Application No: A/76/21/HH
Site Address: Fairhaven North Drive Angmering BN16 4JJ
Description of works: Erection of single storey rear extension.

Thank you for your internet representation made on 14th May 2021 which has been recorded as no objection with the comments as follows:

Disc	PLANNING	Scale	1:50, 100, 500 & 1250 @ A1	Disc Ref	102
Date	APRIL '21			Drawing Number	AL-100a

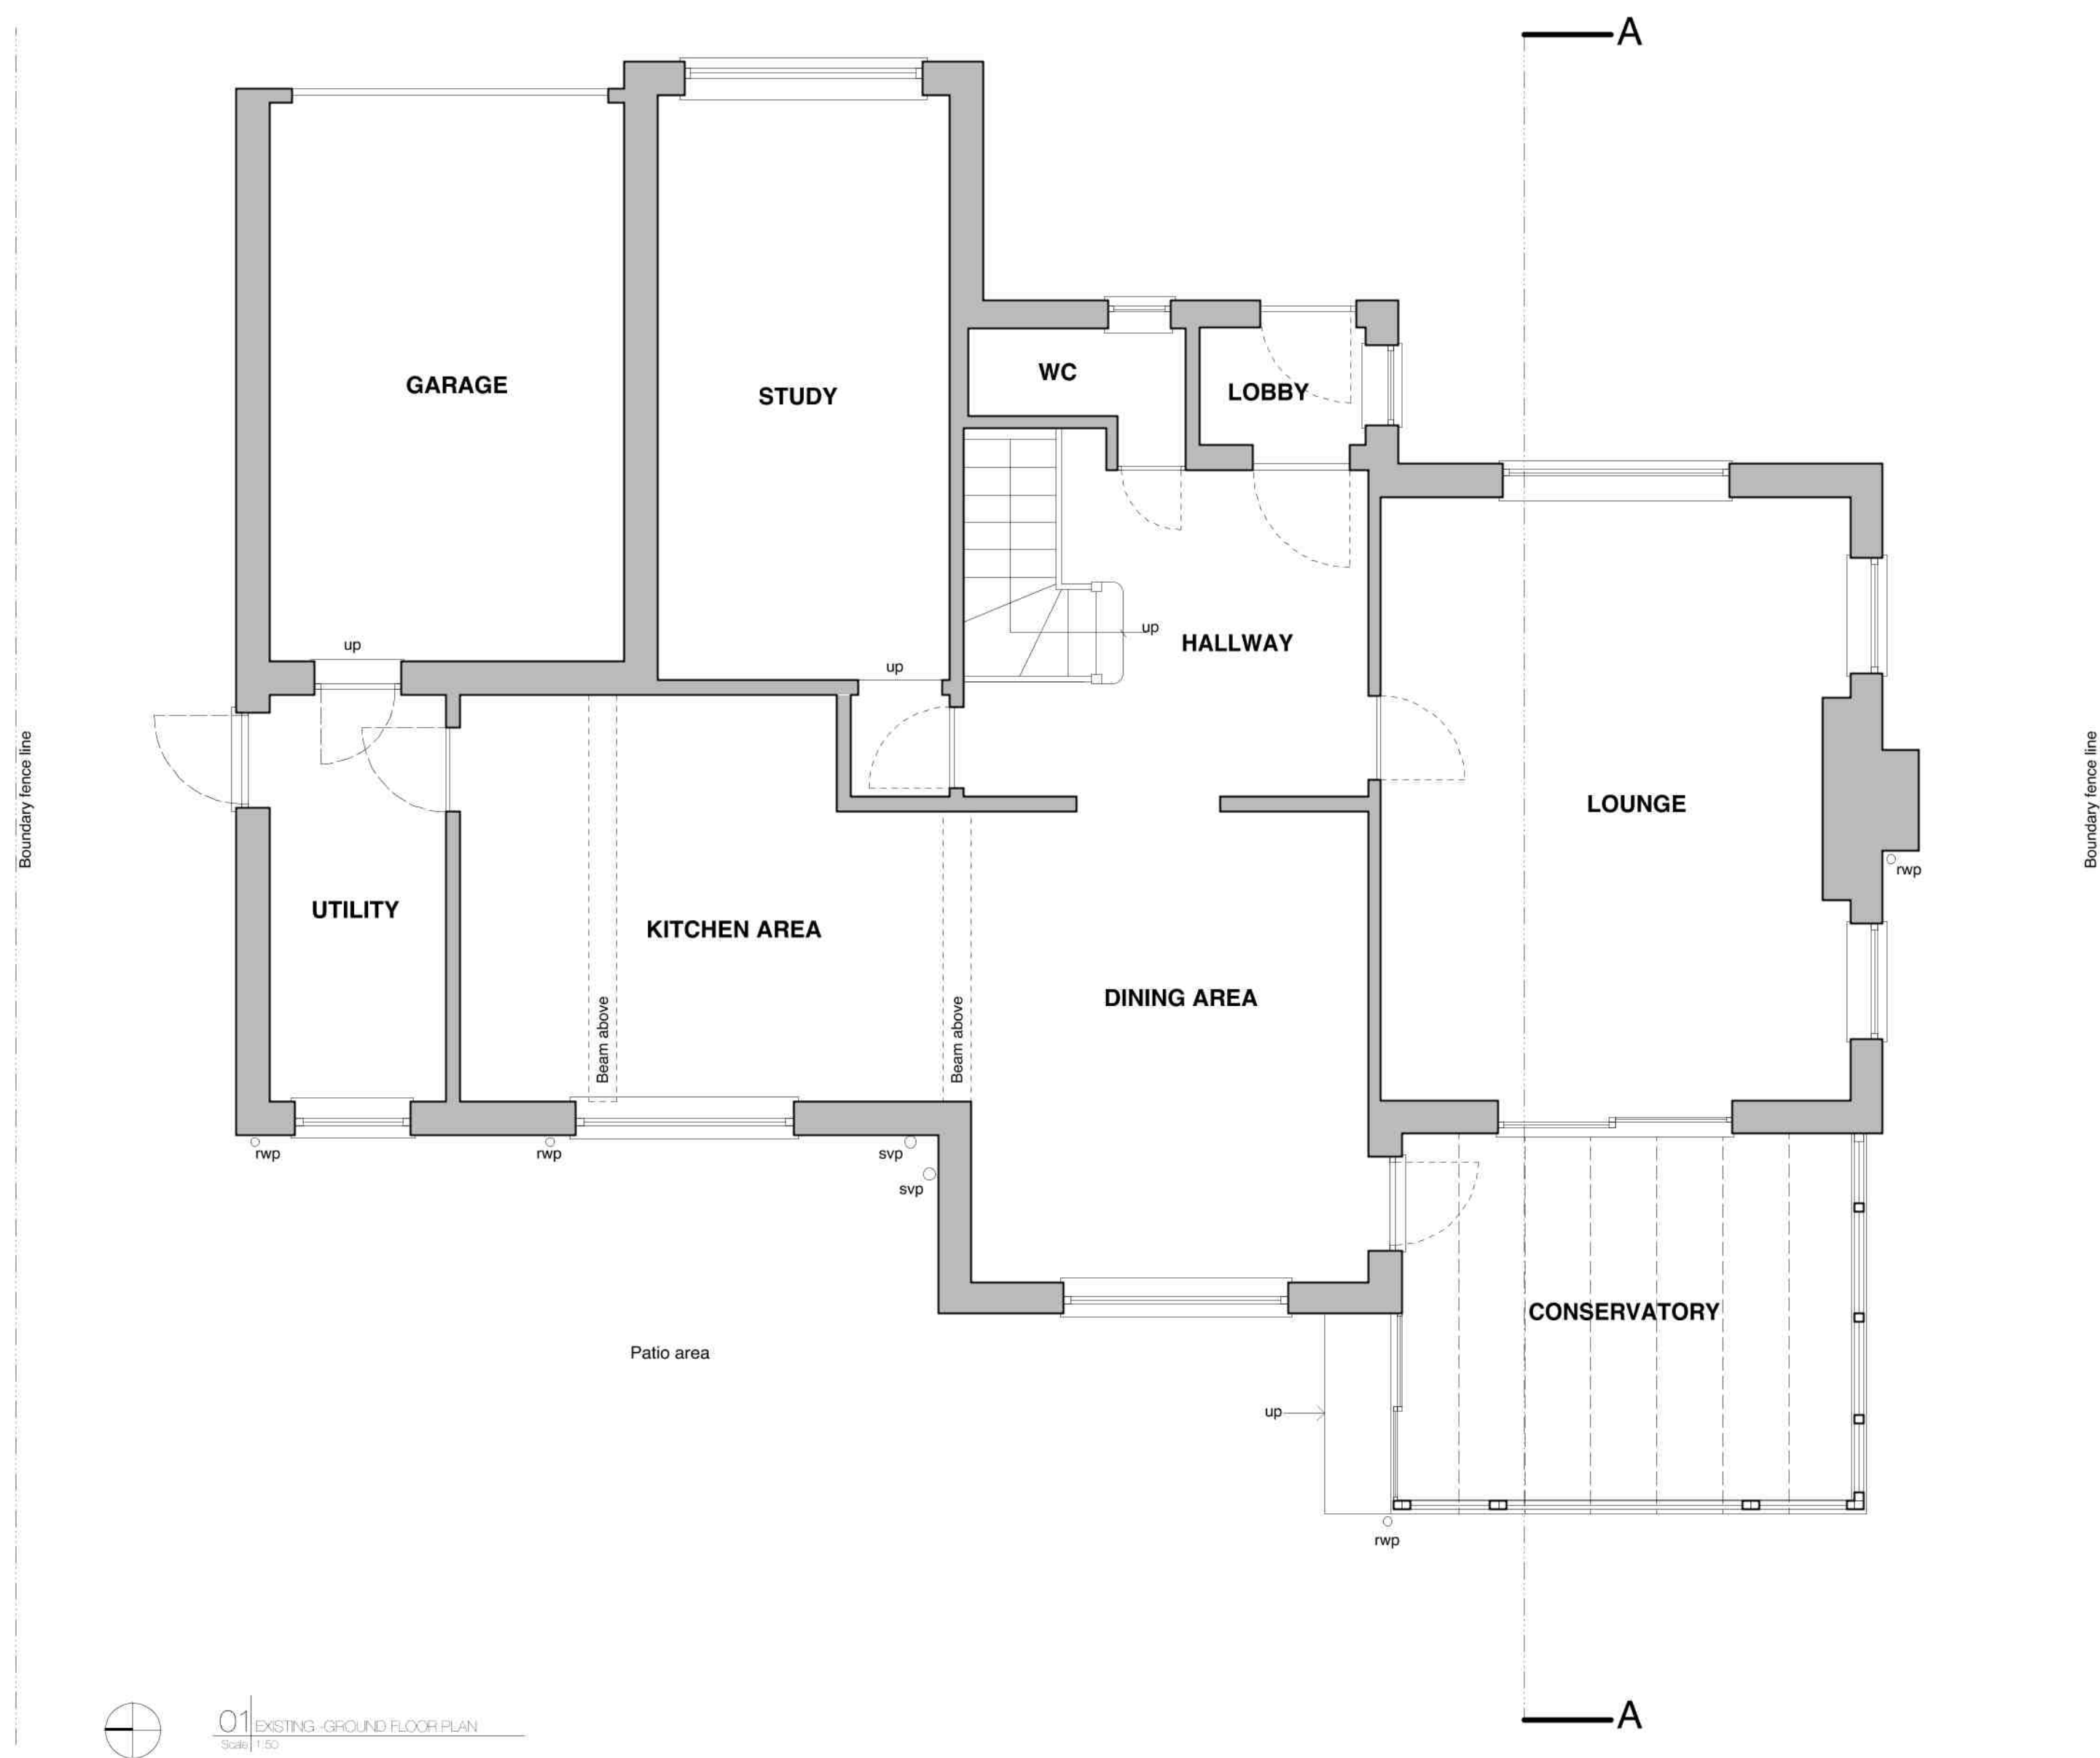
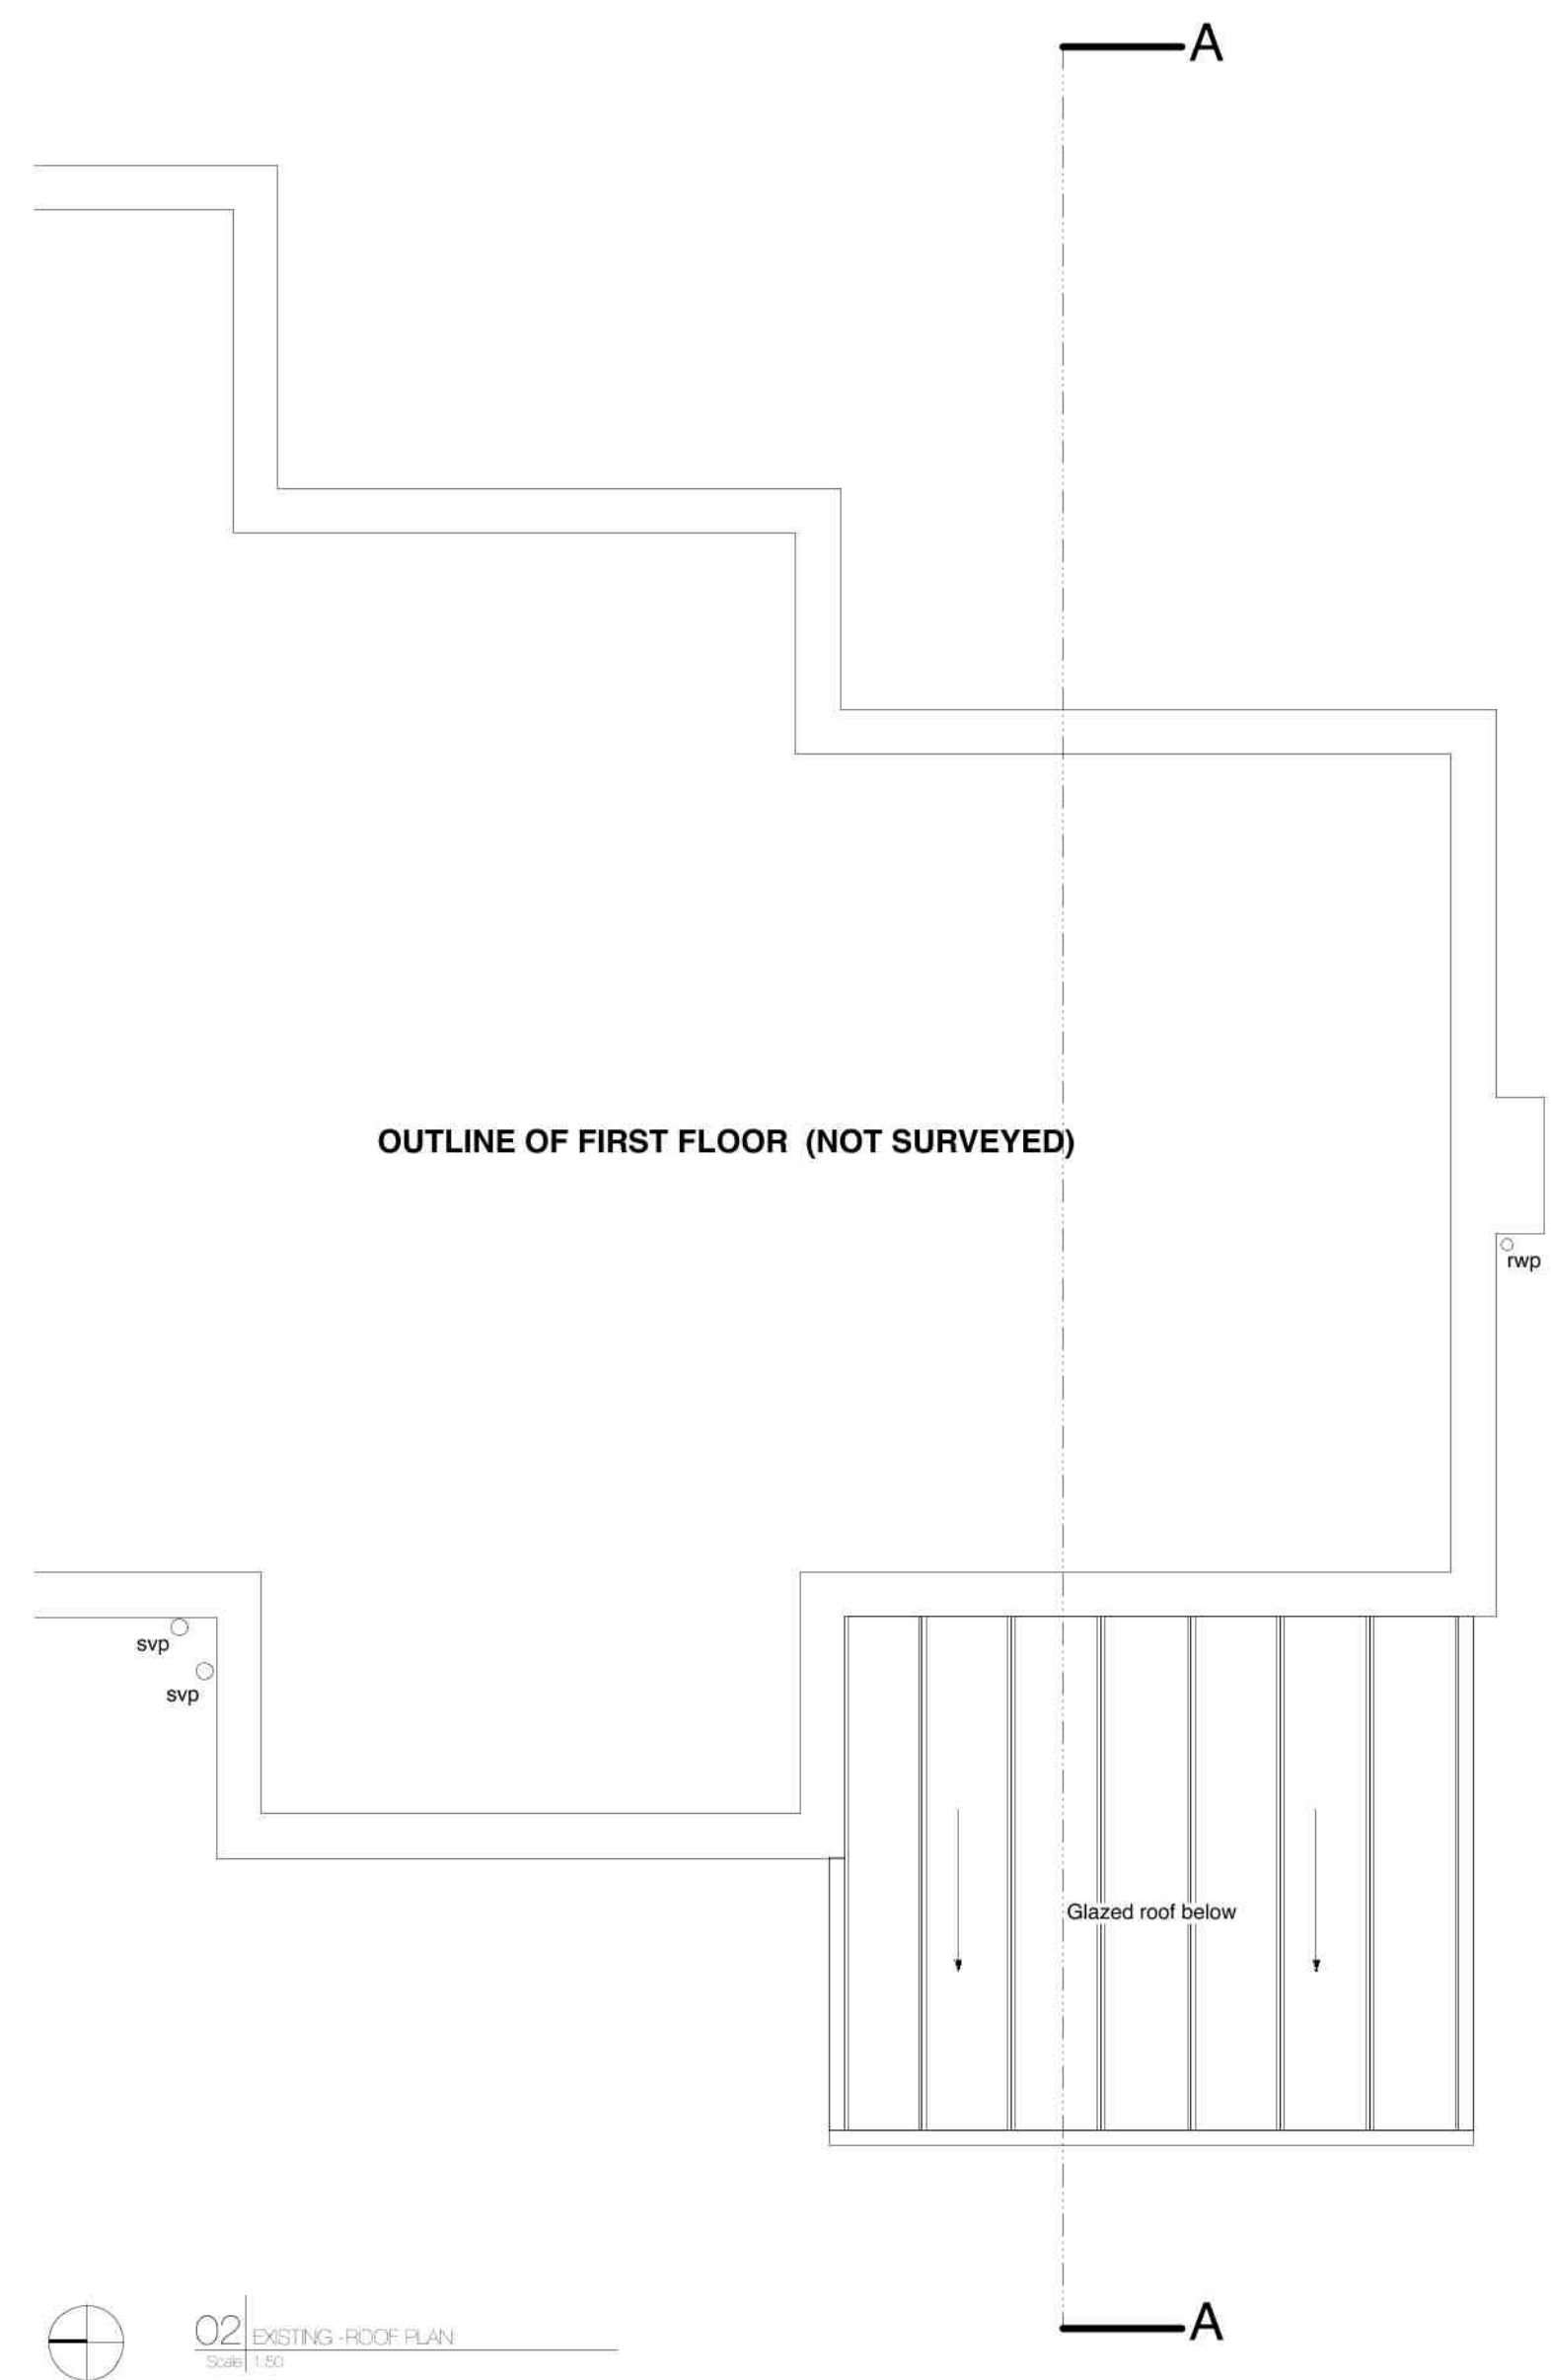
Flat roof lights comply with any dark night skies policy in the NPPF and ADLP. Concern for the neighbour as this extends the rear building line and is adjacent to the neighbour open space.
